DELEGATED DECISION FOR DISCHARGE OF CONDITION A1 - NOTIFICATION OF A PROPOSED DEVELOPMENT UNDER LOCAL OR PRIVATE ACTS OR ORDER

Reference no. 2026/CL/90568/W

Bridge MVL3/44, Huddersfield
Narrow Canal, Marsden,
Huddersfield, HD7 6NQ

Prior approval for alterations to
bridge MVL3/44, Huddersfield
Narrow Canal (within a Conservation
Area)

Drawing Title
**Prior Approval - MVL3/44
Huddersfield Narrow Canal
Existing and Proposed
Elevation and Section**

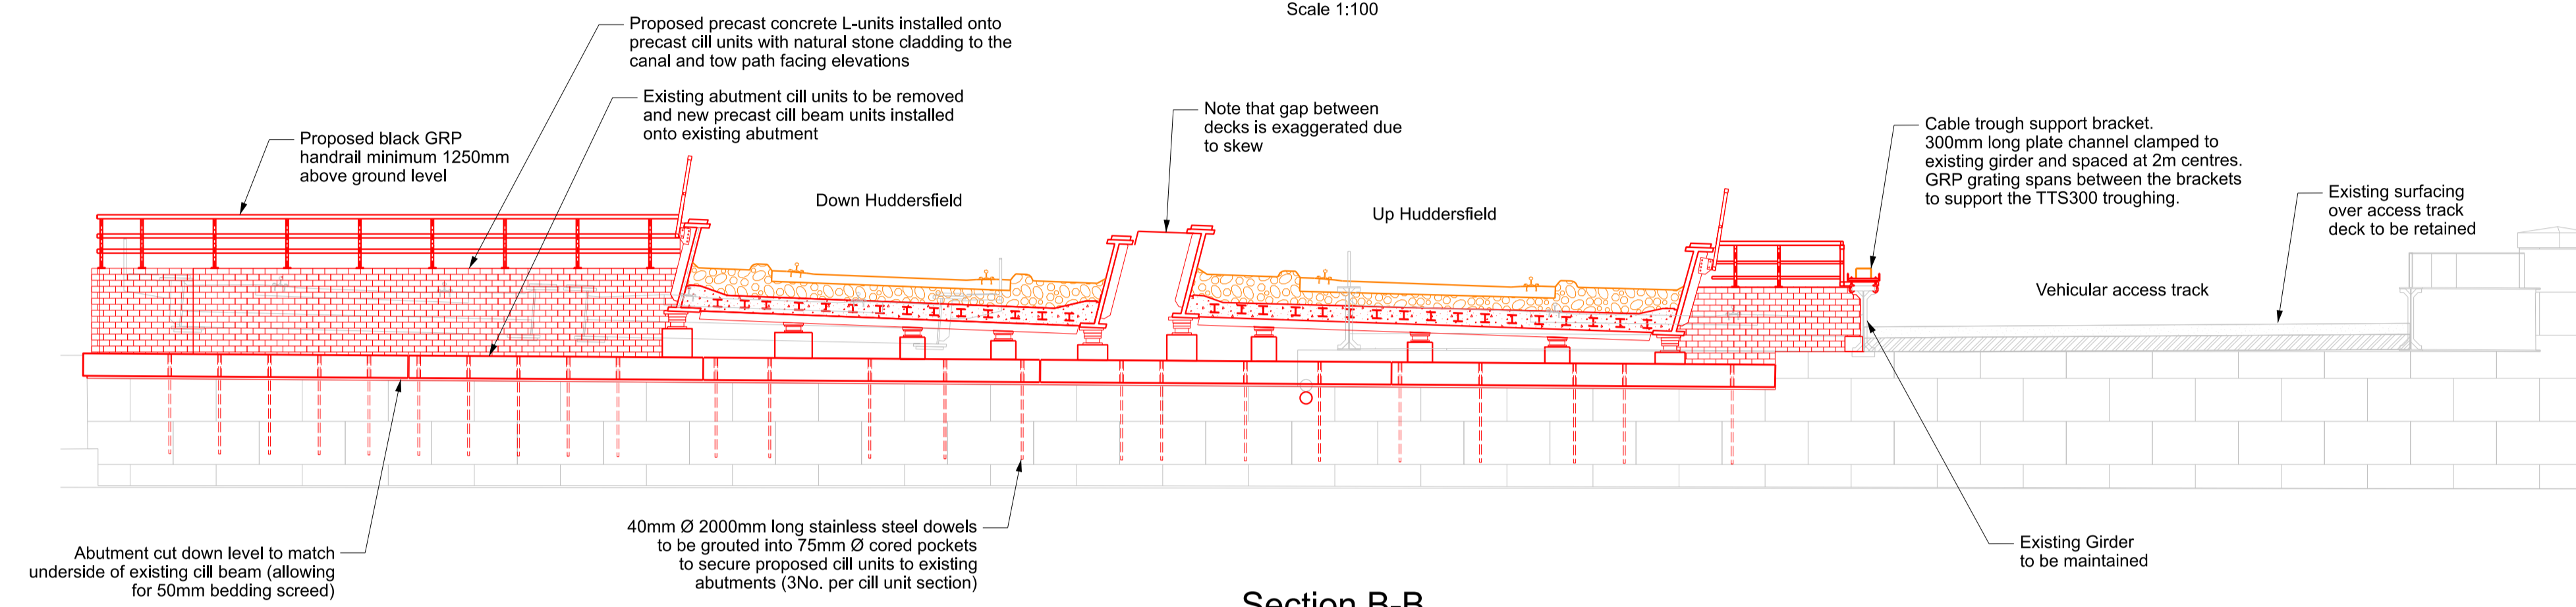
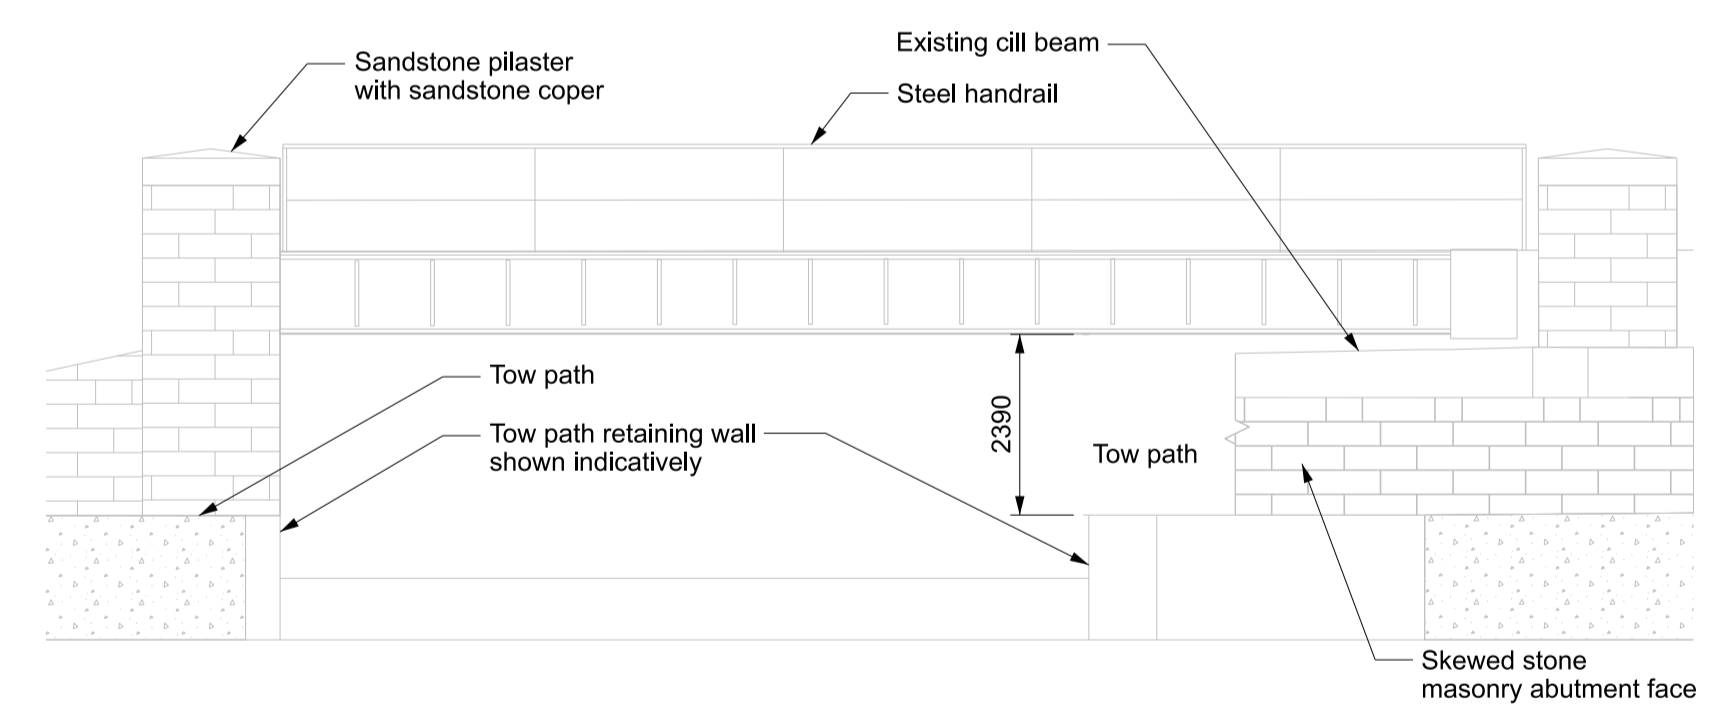
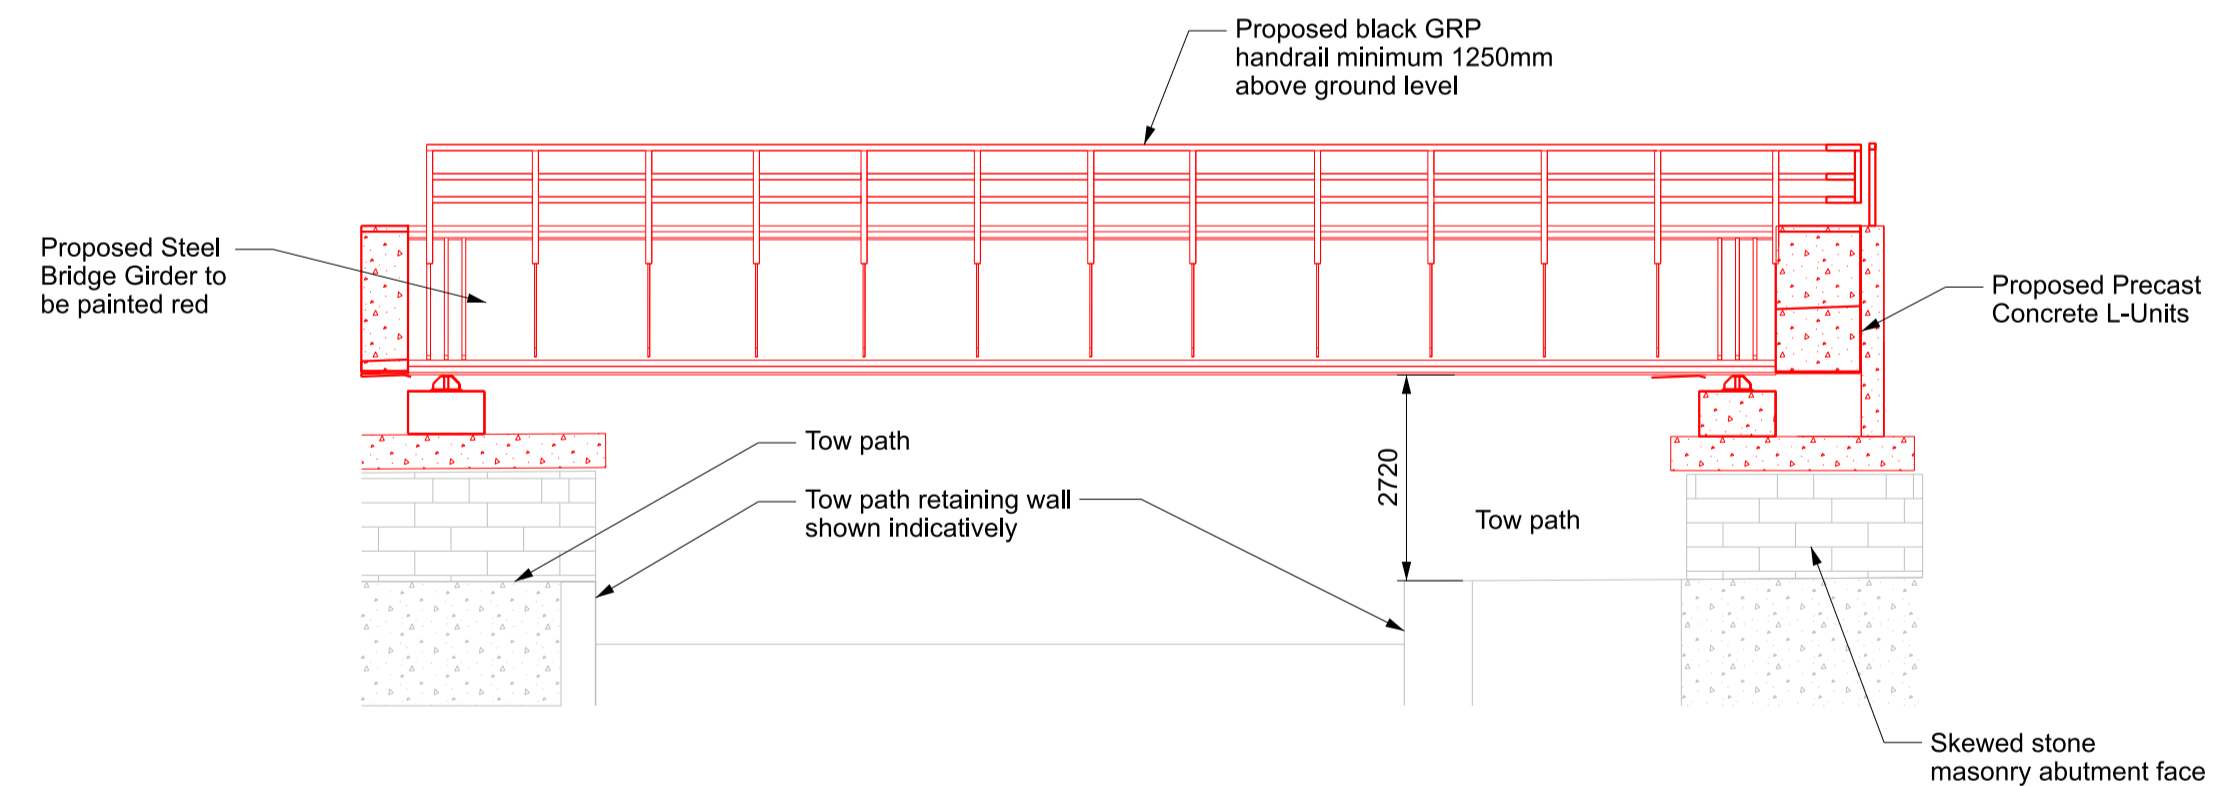
There are some concerns raised of the proposed loss of natural stone masonry from a prominent location within the Conservation Area and the setting of a Listed Building. Please could you consider options to retain features and original natural materials or replacement to be more in keeping with the setting.

We note from the extra visualisations submitted, that the proposed works will involve natural coursed stone to match existing (above and below), except for the concrete cill beam in between to match existing.

Stone cladding is already proposed as part of the bridge works but it's difficult to capture such design detail on the elevation drawings owing to the skewed geometry of the bridge. Therefore, we have attached visualisations before and after the proposed works which allows a better understanding of the visual appearance of the works.

- New natural stone shall match existing in terms of type, colour, texture, finish and method of coursing.
- New concrete shall match existing concrete.
- Mortar shall be an appropriate lime mortar to be finished flush or slightly recessed (not strap pointing.)
